**RE: Bella Vista Assisted Living, 13101 Constitution Avenue NE
Grading Plan and Drainage Plan
Engineer's Stamp Date 4-15-2015 (File: J22-D067)**

Based upon the information provided in your submittal received 4-16-15, the above referenced Grading Plan cannot be approved for Building Permit until the following comments are addressed:

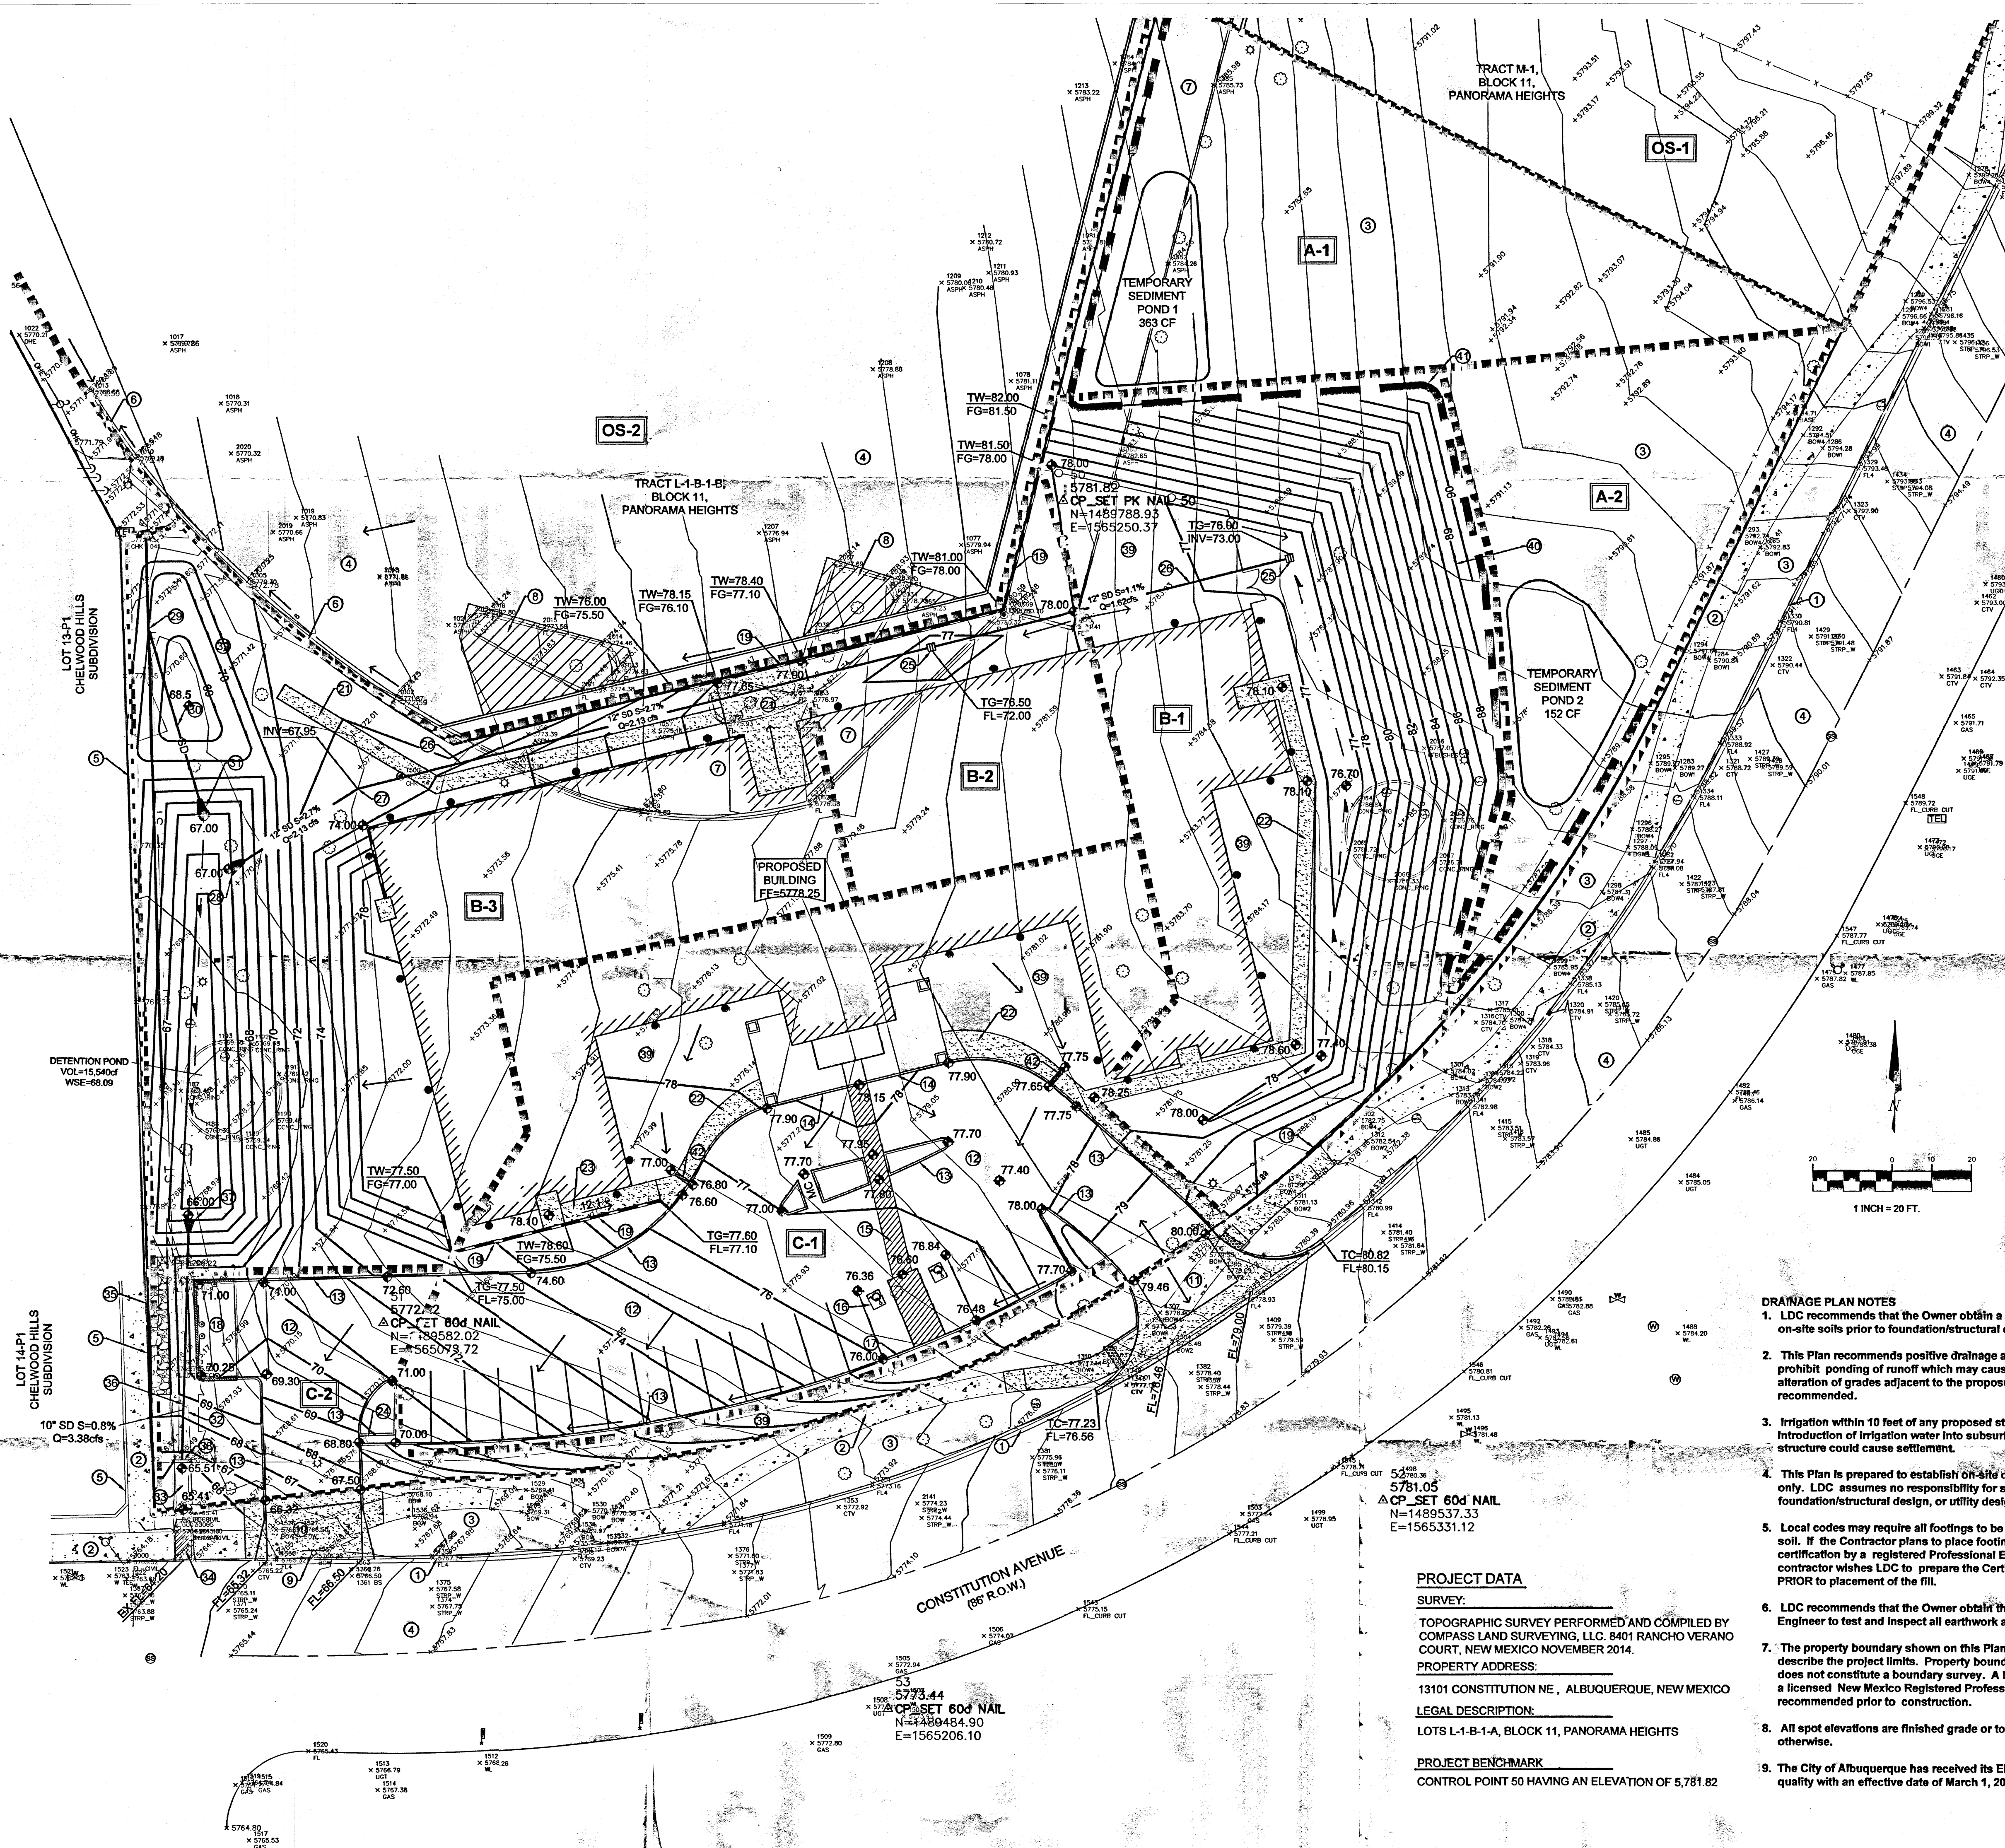
- 1) On the Grading and Drainage Plan itself, label basins, show basin boundaries, and roof drain locations.
- 2) Basin B-2 appears to be much more than 36% impervious since the new building covers a large portion of Basin B-2 according to Basin Map. Check impervious areas for the basins.

- 3) On the Grading and Drainage Plan, show retention areas with additional proposed contours and/or spot elevations which correspond to Figure 7 of your drainage report. Typically, in areas where the first flush is being retained around inlets, the inlet grates are slightly raised above the proposed ground to create the retention areas. The established retention areas should correspond with the volumes computed in Figure 7.

- 4) On the Grading and Drainage Plan, label all storm drain slopes and flows that correspond to the Drainage Structure Inventory in the report. Label all storm drain inverts.

- 5) Keyed Notes 37 and 36 look are duplicated and look misplaced on the plan view along the east slope of the detention pond.

- 6) On the plan, one of the storm drains changes in size from 12" to 18", but this does not match the Drainage Structure Inventory. If it was meant to change the pipe size to 18", call the location out on plan or else change pipe size to show 12".
